# KITTITAS COUNTY DEPARTMENT OF PUBLIC WORKS

## MEMORANDUM

TO: Mackenzie Moynihan, Community Development Services  
FROM: Christina Wollman, Planner II *dw*  
DATE: August 1, 2007  
SUBJECT: M. Schmidt Short Plat

DWN BY <b>G. WEISER</b>	DATE <b>06/07</b>	JOB NO. <b>07128</b>
CHKD BY <b>D. NELSON</b>	SCALE <b>1"=100'</b>	SHEET <b>1 OF 2</b>

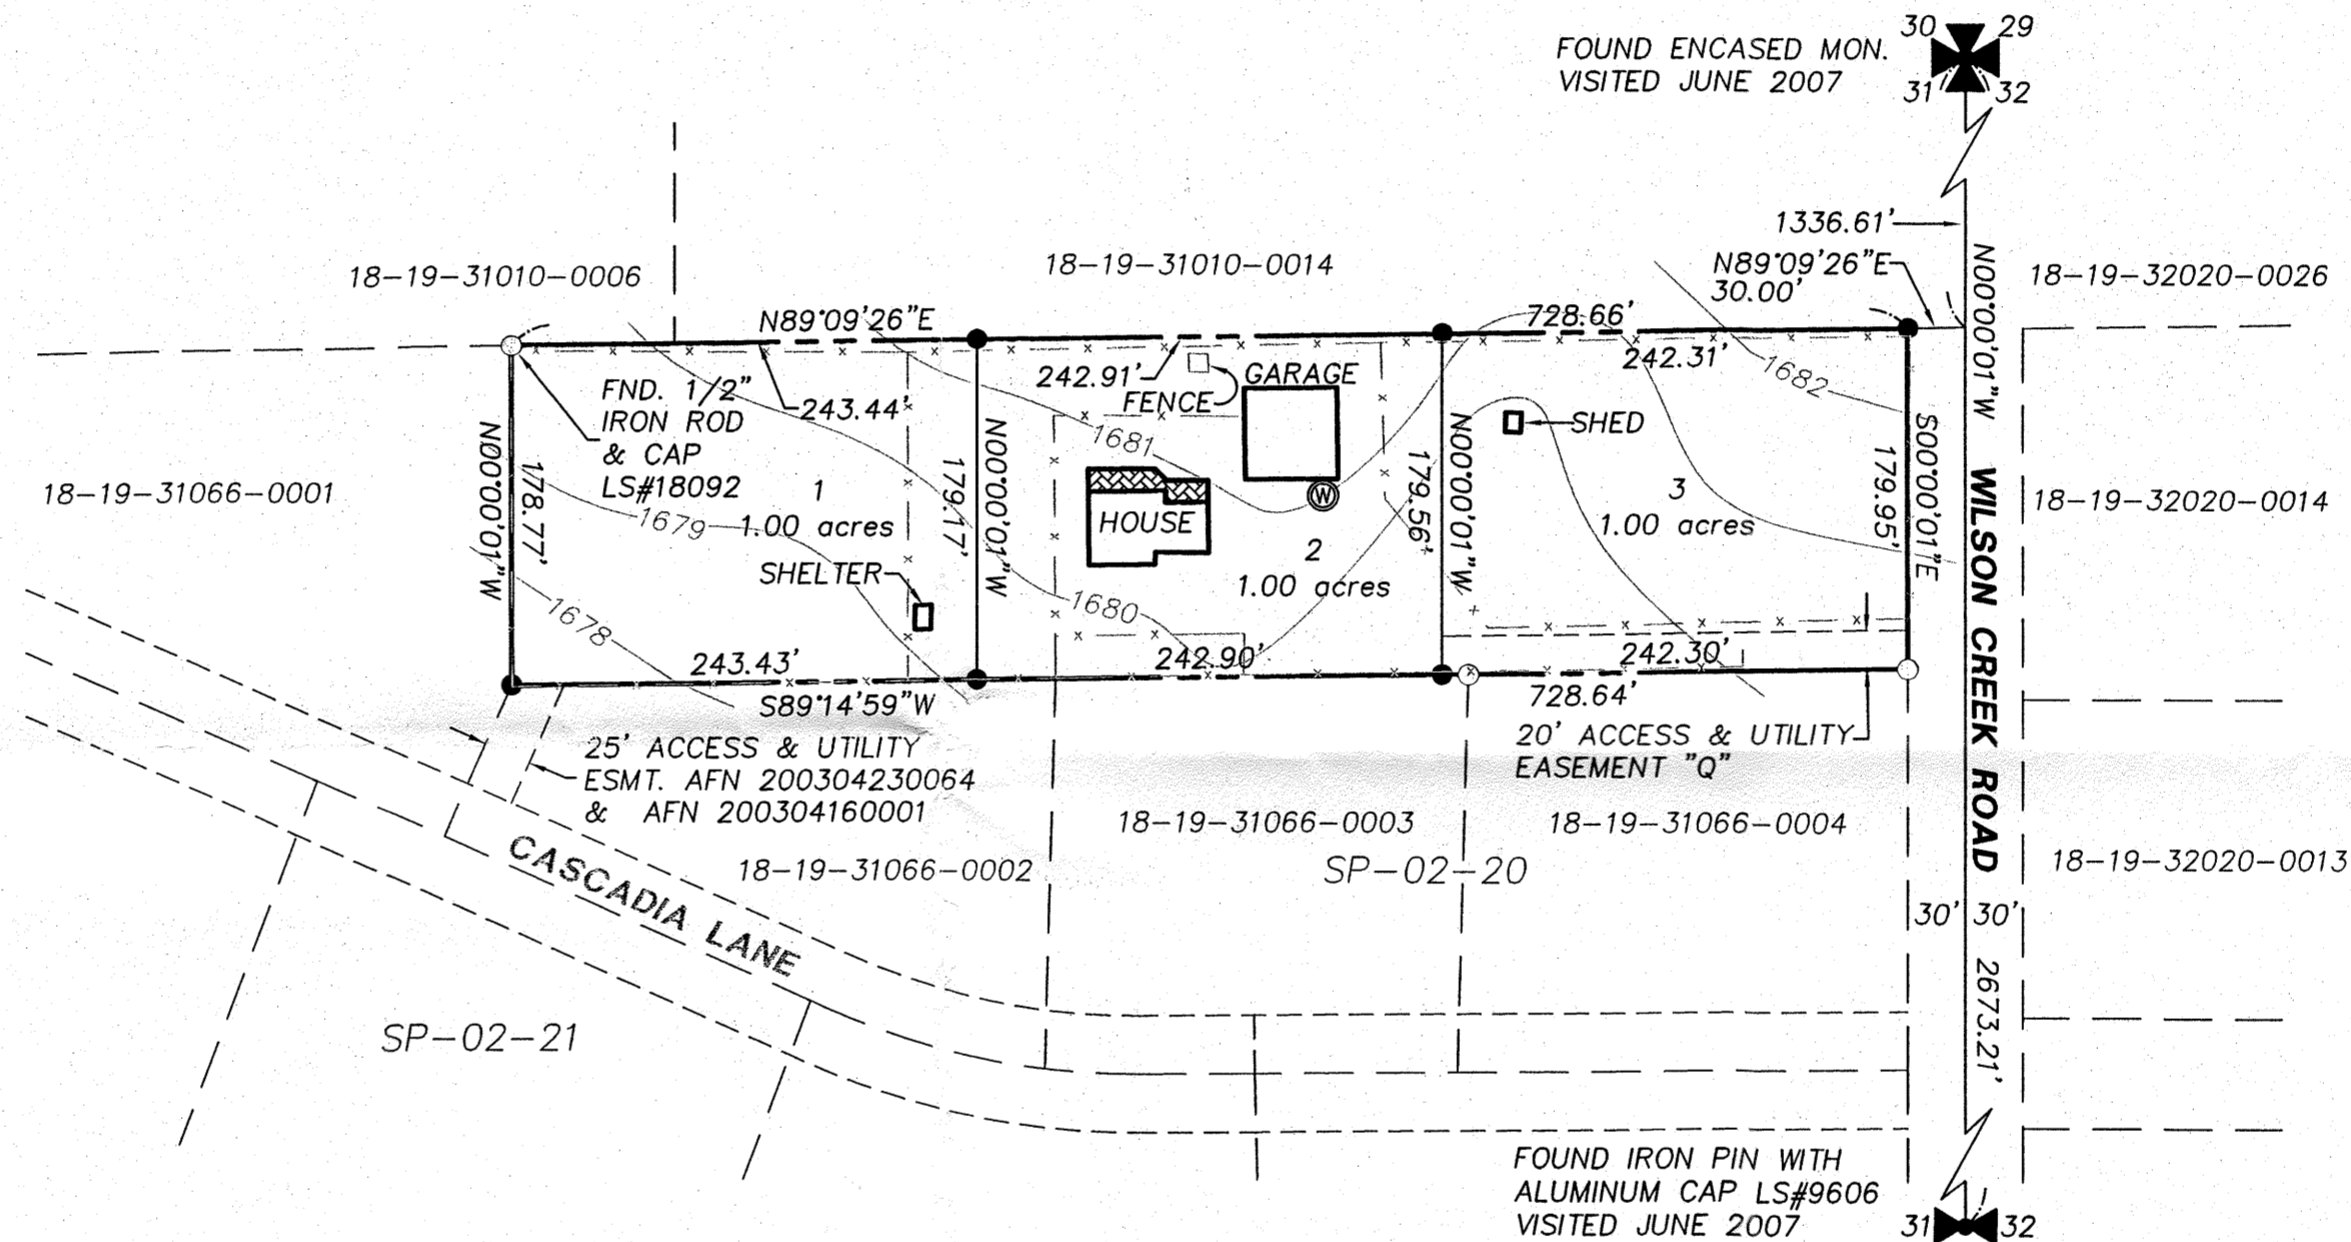
2. Cascadia Lane: The easement width for Cascadia Lane shall be shown on the plat.
3. Cascadia Lane Private Road Improvements: Access from Wilson Creek Road to the entrance to Lot 1 shall be constructed to meet or exceed the requirements of a High-Density Private Road and serve no more than 14 tax parcels. See Kittitas County Road Standards, 9/6/05 edition.

- a. Access easements shall be a minimum of 40' wide. The roadway shall have a minimum width of 20', with 1' shoulders, for a total width of 22'.
  - b. Minimum centerline radius will be 60'.

- c. Surface requirement is for a minimum gravel surface depth of 6".
  - d. Maximum grade 8% flat, 12% rolling or mountainous.
  - e. Stopping site distance, reference AASHTO.

4. Cul-de-Sac: Permanent deadend streets shall have a turn-around having an outside right-of-way easement diameter of at least 110' (55' radius) at the closed end. See Kittitas County Road Standards, 9/6/05 edition.

- a. Cul-de-sac design, reference 2006 International Fire Code.
  - b. Contact the Fire Marshall regarding any additional cul-de-sac requirements.
5. Joint-Use Driveway: Access from Wilson Creek Road to Lots 2 and 3 shall be constructed to meet or exceed the requirements of a joint-use driveway. A joint-use access shall serve no more than two tax parcels. See Kittitas County Road Standards, 9/6/05 edition.

- a. Access easements shall be a minimum of 20' wide. The roadway width shall have a minimum width of 12'.
  - b. The surface requirement is for a minimum gravel surface depth of 6".

Single-Use Driveway: Access from Cascadia Lane to Lot 1 shall be constructed to meet or exceed the requirements of a single-use driveway. A single-use access shall serve no more than one lot. See Kittitas County Road Standards, 9/6/05 edition.

- a. The roadway shall be a minimum of 8' wide with gravel surface.
- b. Maintenance of driveway approaches shall be the responsibility of the owner whose property they serve. The County will not maintain accesses.
